Item No. **Report of the Interim Director of Planning, Regeneration & Public Realm**

Address 69 HIGH STREET RUISLIP

Development: Extension at the front of the property above the shopfront to provide 1 x self-contained flat (Use Class C3) at second floor level and erection of a new two storey building at the rear of the property to provide 1 x self-contained flat (Use Class C3) above an open loading bay with associated bin and cycle store.

LBH Ref Nos: **1983/APP/2022/2930**

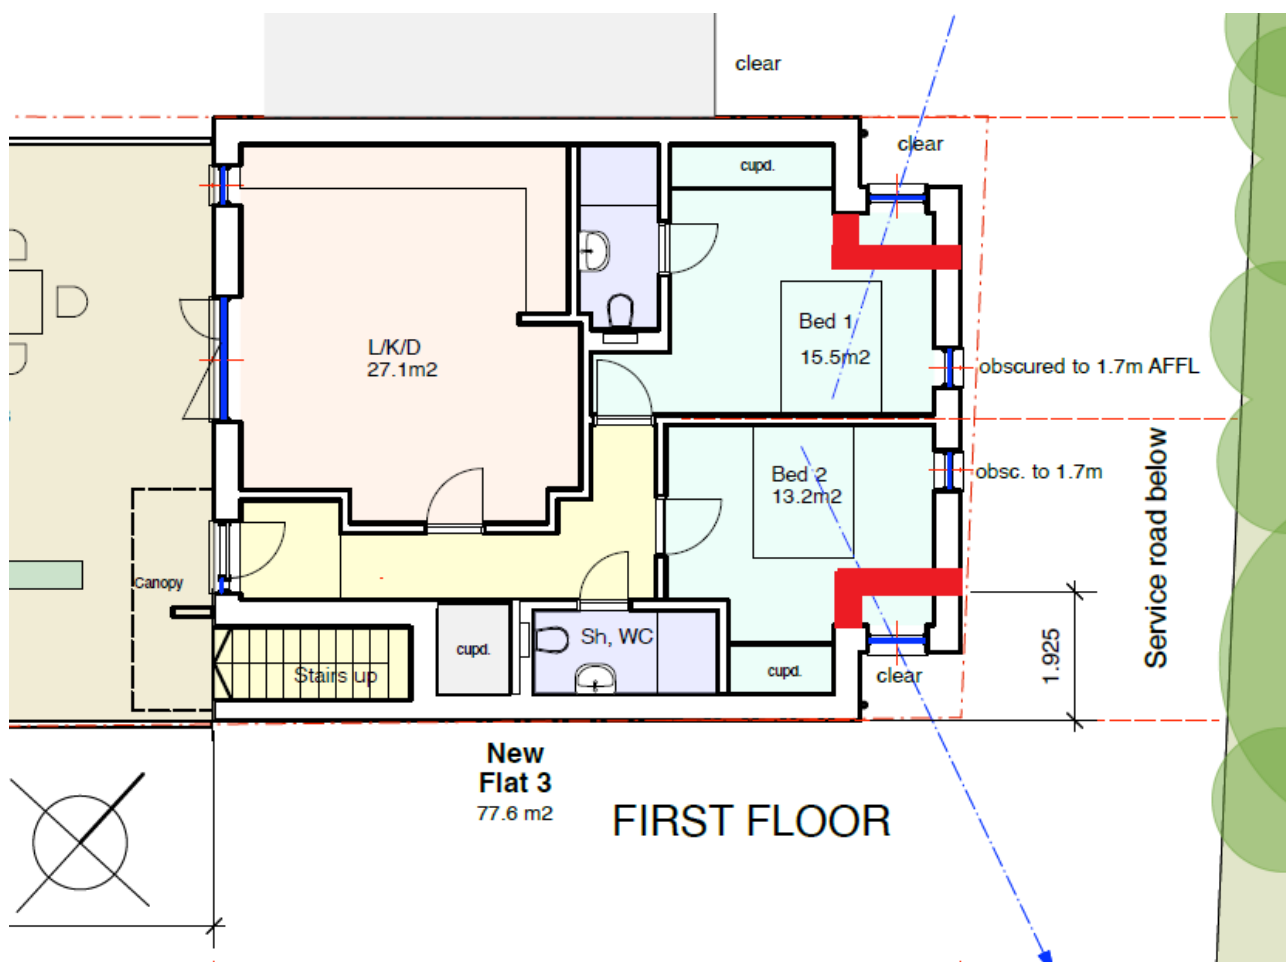
In this instance, the width of the bedrooms are proposed to be widened by reducing the set-ins from the side boundaries to just 1metre. Whilst this would increase the floor area for the new flat, the resulting flat in the new rear building would still be a 2bed 4person flat as per the previous approval. Due to the close proximity of the primary windows to the side boundaries, and the overreliance of borrowed light from and outlook over the neighbouring property, there would be insufficient separation distance to provide and maintain a suitable outlook and adequate daylight. This arrangement is considered unacceptable.

Having regard to the relevant appeal decision, it is considered that bedrooms 1 and 2 of Flat 3 would not maintain an adequate outlook and source of natural light, resulting in substandard living accommodation for future occupiers. The development proposal therefore conflicts with the Housing quality and standards of Policy D6 of London Plan (2021) and Policies DMHB 11 and DMHB 16 of Hillingdon Local Plan: Part Two - Development Management Policies (2020).
